Your Ref: OWPC22055
Our Ref: M/24/19/PL 06-03-2019
Please ask for:
Andrew Wood

Replacement residential dwelling. This application may affect a Public Right of Way.
3 The Hard Elmer

REV.	DESCRIPTION	DATE
1	PROJECT REPLACEMENT DWELLING 3 THE HARD ELMER SANDS WEST SUSSEX	
2	CLIENT Ms D HUANG	
3	DRAWING TITLE PROPOSED PLANS, ELEVATIONS & SITE PLAN - DRAFT ISSUE ONLY	
4	SCALE VARIOUS @ A1	DRAWN BY MUM
5	DATE JAN 19	
6	DWG NO PLO1	REV. /

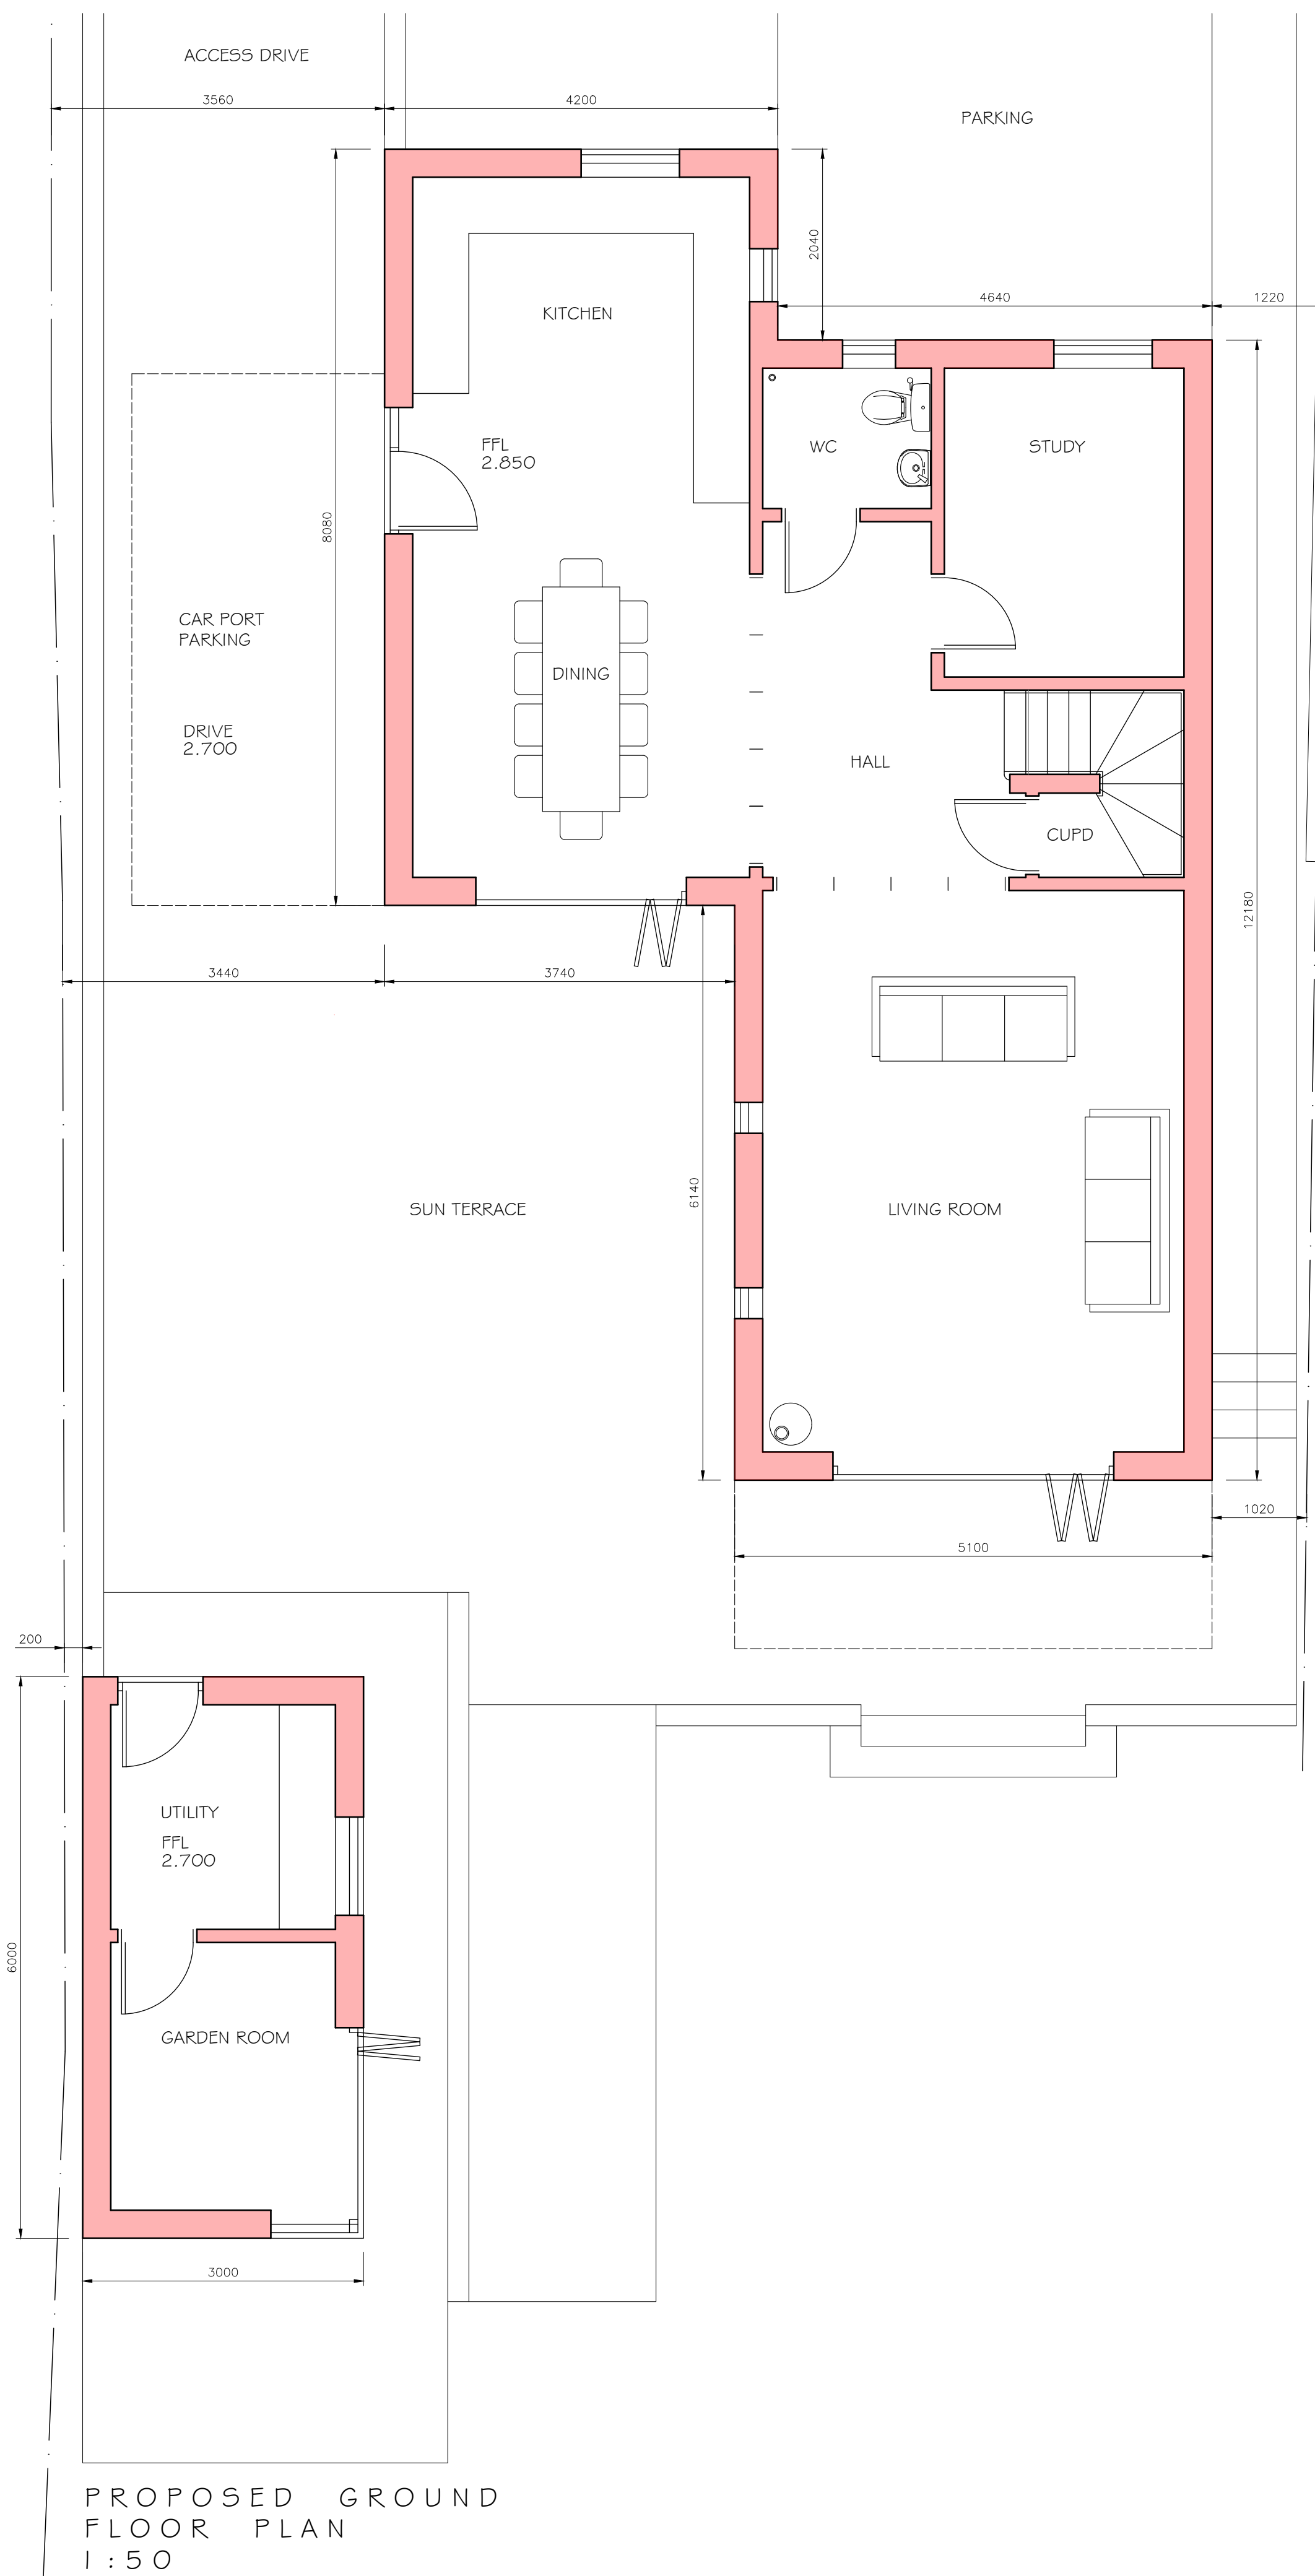
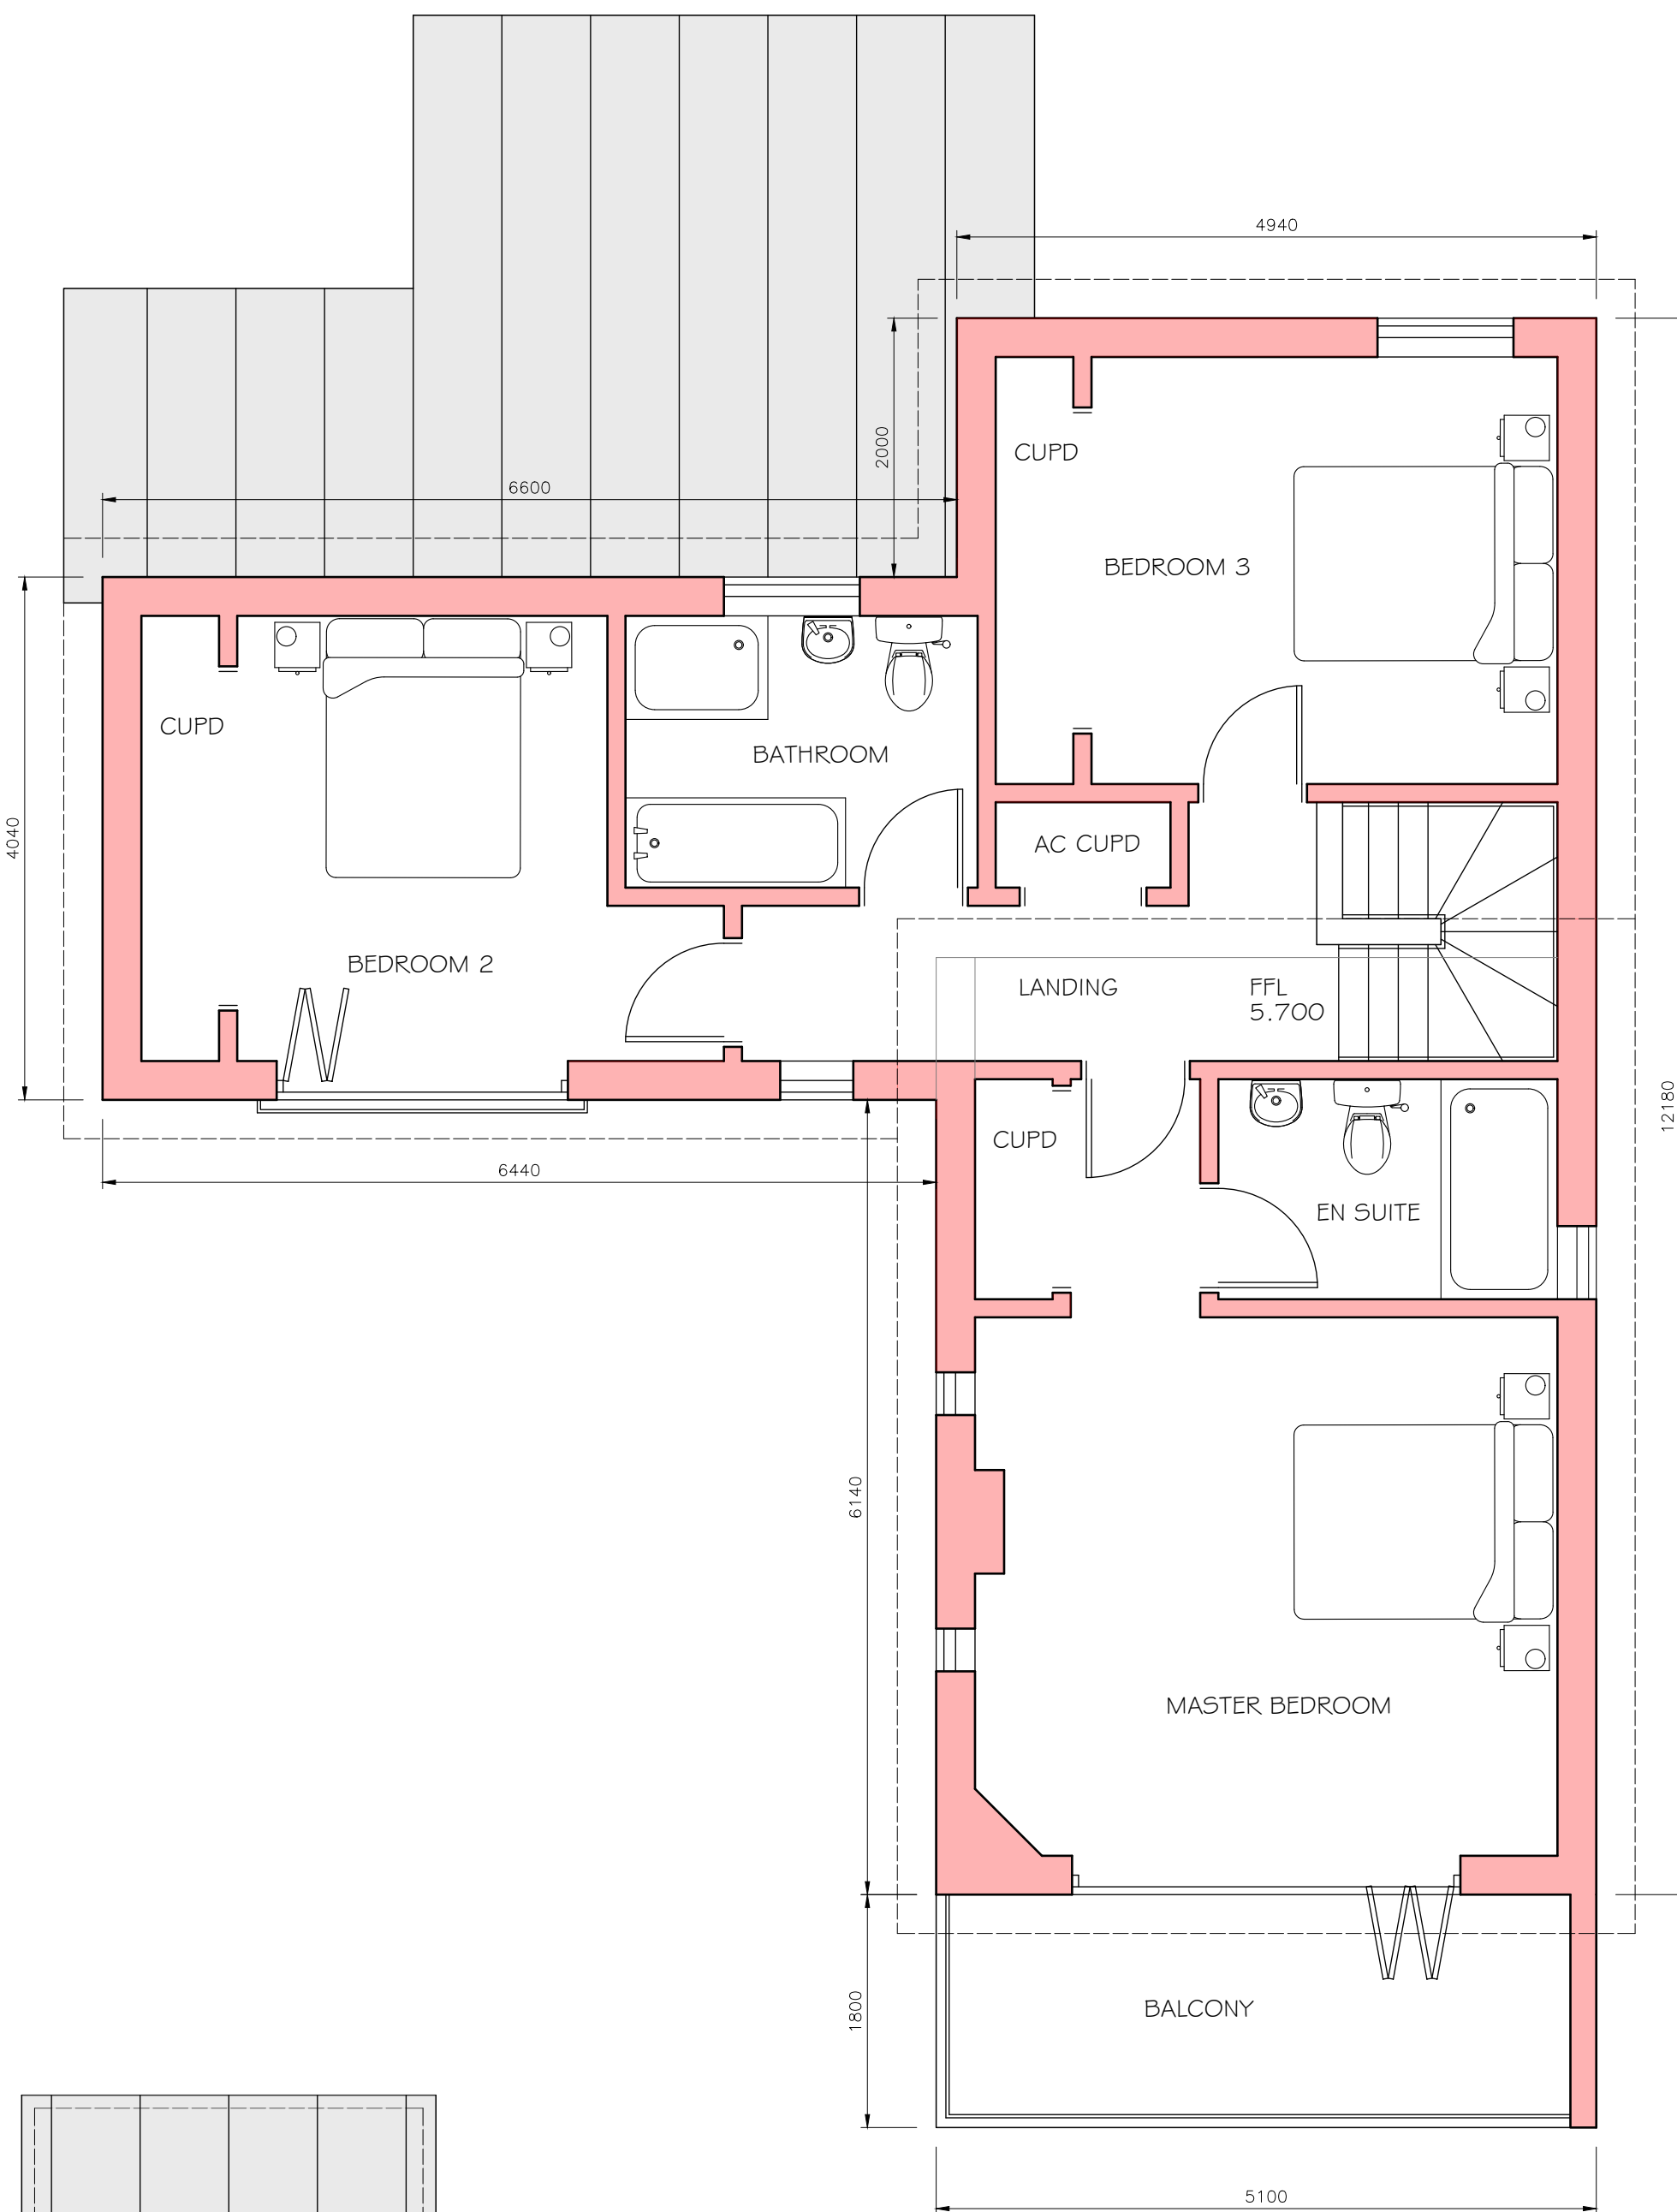
According to the plans, there is a reduction planned for "the garden feature". We would point out that this is NOT a garden feature but the original sea defence. This is continuous across several properties on The Hard. We are very concerned that reducing this sea defence will seriously compromise the effectiveness, especially with the Environment Agency's concerns regarding rising sea levels and constant warnings of more and stronger storms in the future due to global warming. We trust you will consider the implications this action may cause.
